Helios Renewable Energy Project

Responses to S51 advice

Title:
Helios Renewable Energy Project
Order 2024
Land Plan (Sheet 3 of 4)
Document 3.1C
Regulation 5(2)(i)

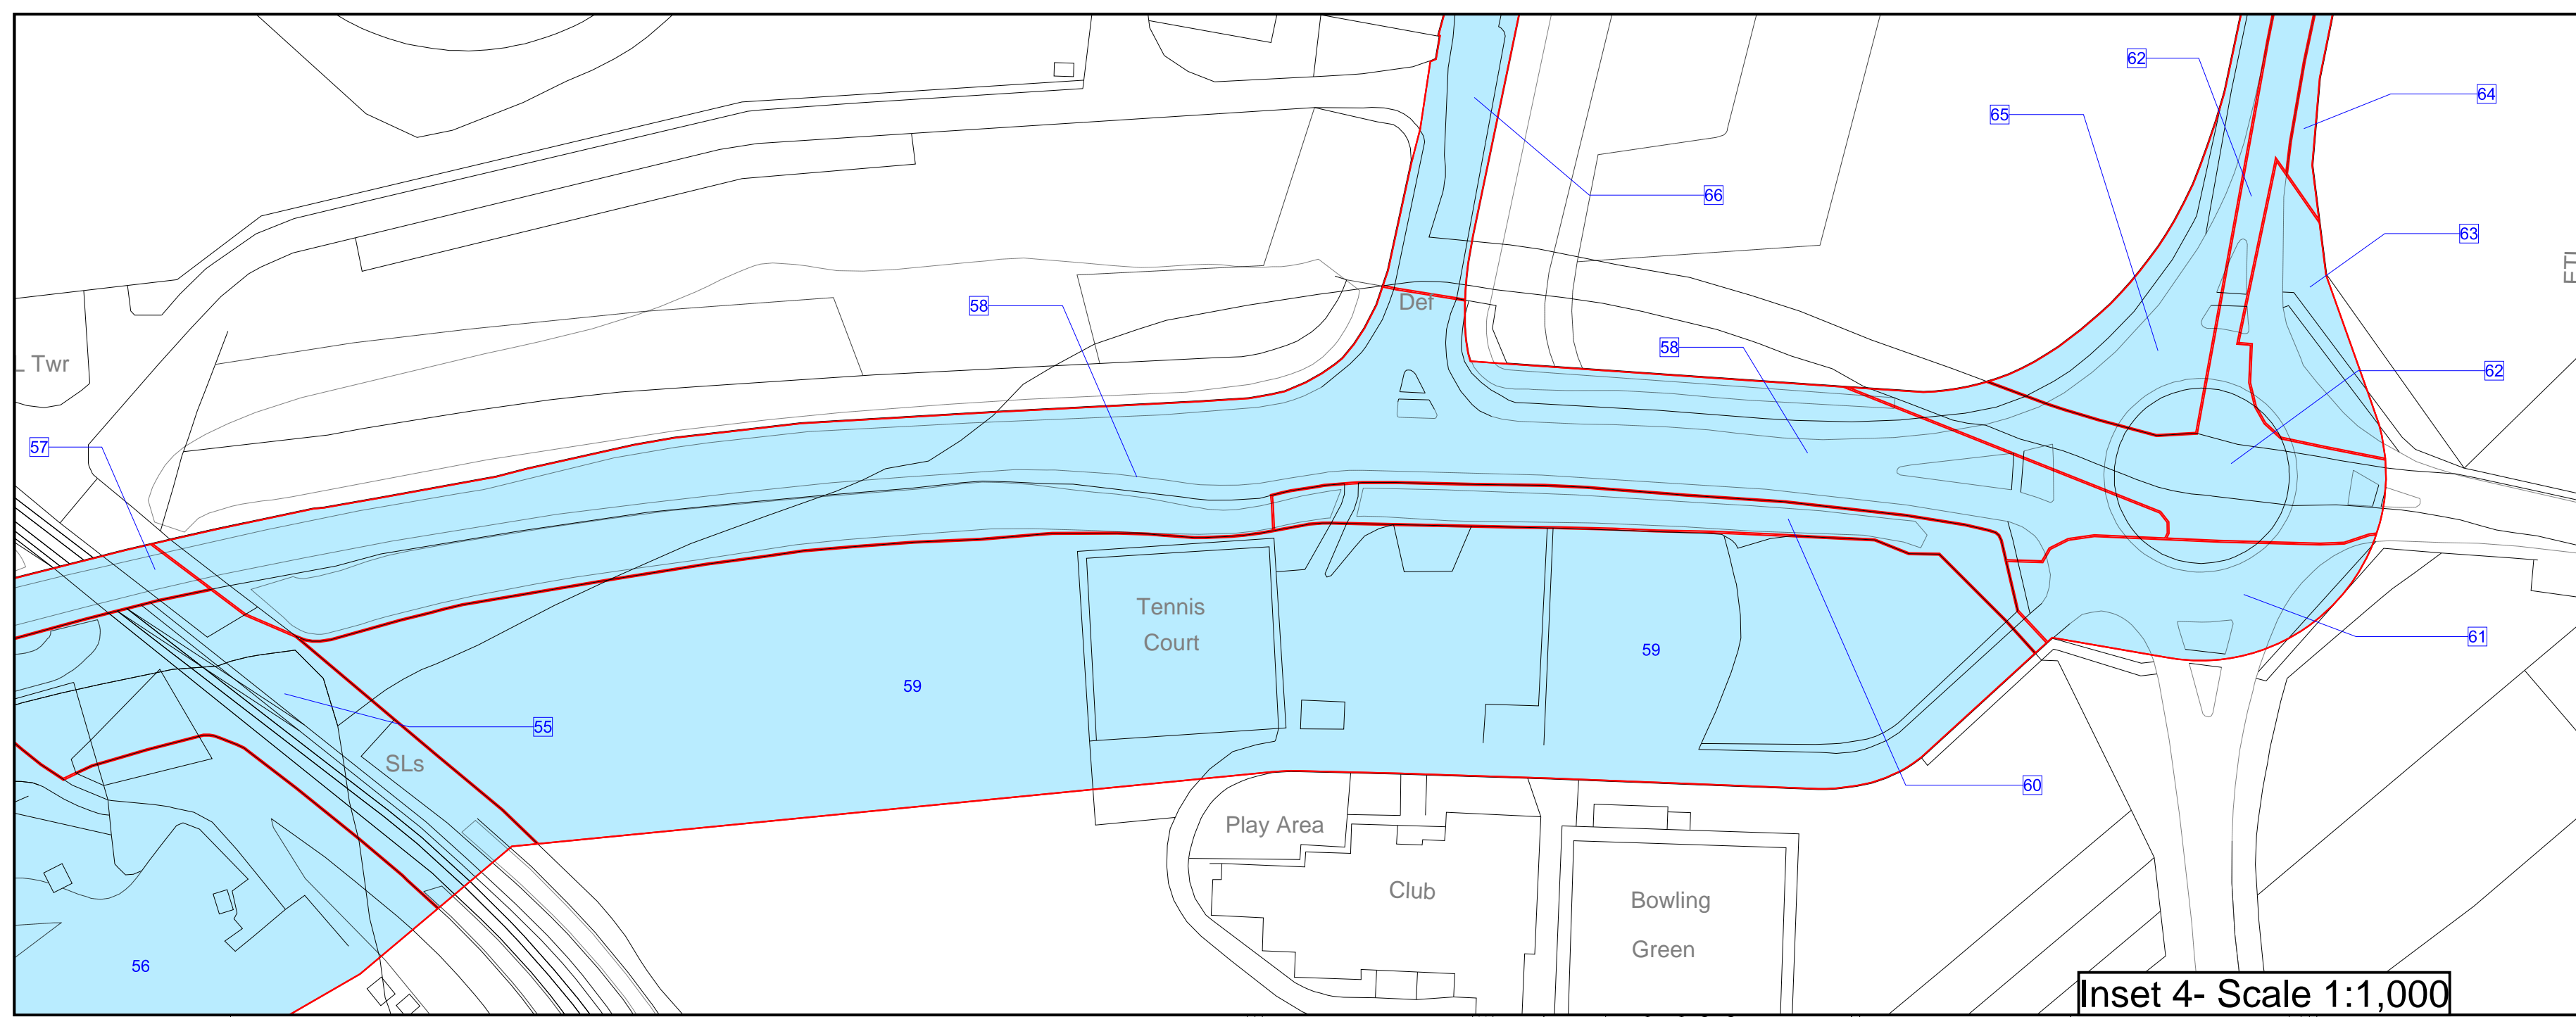
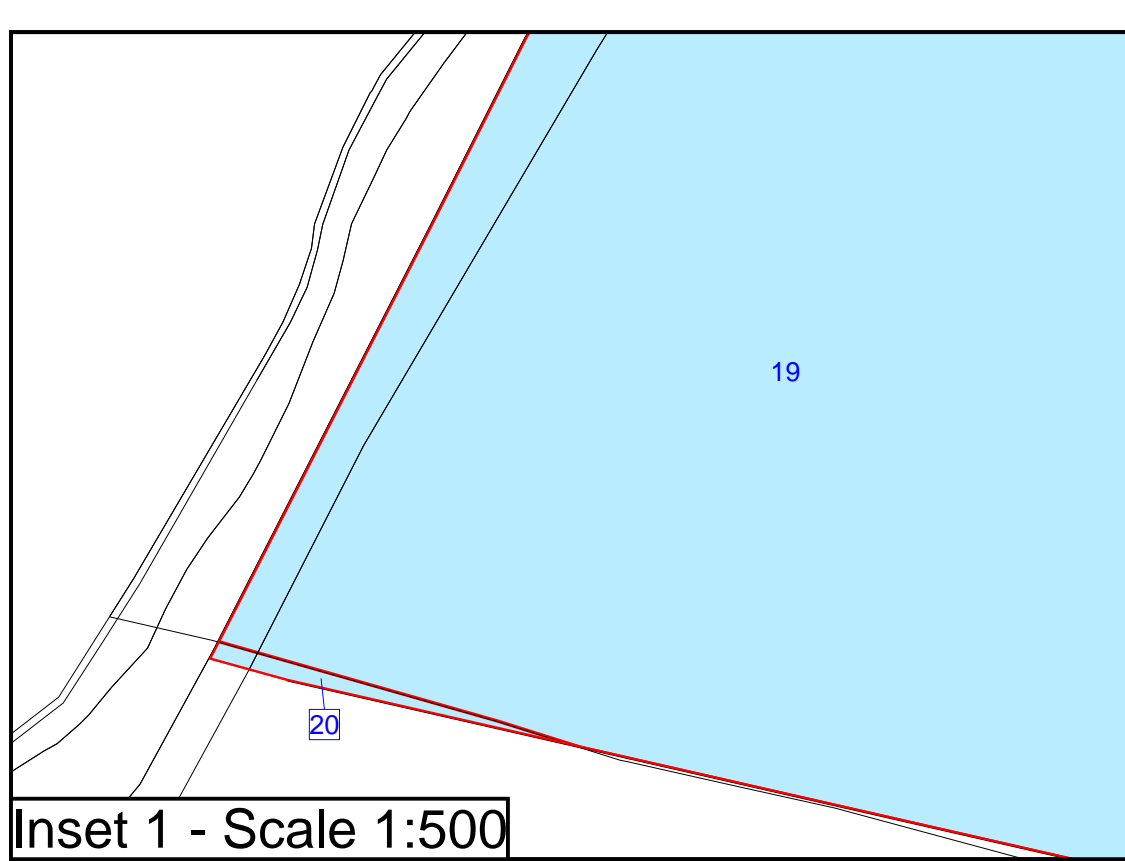
The DCO seeks powers to acquire permanent acquisition of new rights (article 23), acquisition of subsoil (article 26) and temporary use of land to permit construction and maintenance (articles 30 and 31). The land related to all these powers sought is shown edged red and shaded blue on the land plans. Greater clarification as to whether all powers are sought for the whole area or if different powers relate to individual plot numbers would be beneficial.

The Applicant is not seeking the permanent acquisition of any land through the draft DCO. Whilst powers of temporary possession and use are sought across the Order land, there are no areas within which such powers are sought in isolation. Rather, for the reasons given below, where the Applicant is seeking powers of temporary possession and use, powers for the permanent acquisition of rights are also sought. As such, all of the Order land is shown shaded blue on the Land Plans.

The Land Plans, the Book of Reference and the Statement of Reasons should be read in conjunction with the draft DCO (and, in particular, Schedule 7 thereto). Article 23 of the draft DCO authorises the undertaker to permanently acquire rights or impose restrictive covenants over the Order land. It further provides that, in respect of the Order land set out in Schedule 7, the undertaker's powers of compulsory acquisition are limited to the permanent acquisition of such rights and the imposition of restrictive covenants for the purposes specified in that Schedule.

Schedule 7 sets out each area of land over which new rights may be permanently acquired by the undertaker, as well as the nature of those rights. The permanent acquisition of rights and imposition of restrictive covenants are sought in respect of the entirety of the Order land (i.e. each plot of land identified on the Land Plans and set out in the Book of Reference). Such rights are, however, sought for different purposes in respect of each plot. The Applicant has chosen to categorise these purposes based on various activities that will require to be undertaken in connection with the construction, operation and maintenance of the authorised development, with each category of rights defined within Schedule 7.

The plot numbers in column (1) of the table within Schedule 7 correlate with the Land Plans and the Book of Reference, and column (2) with the work numbers comprised within the authorised development and set out in Schedule 1 to the draft DCO. Finally, column (3) of the table explains the purposes for which rights may be acquired.
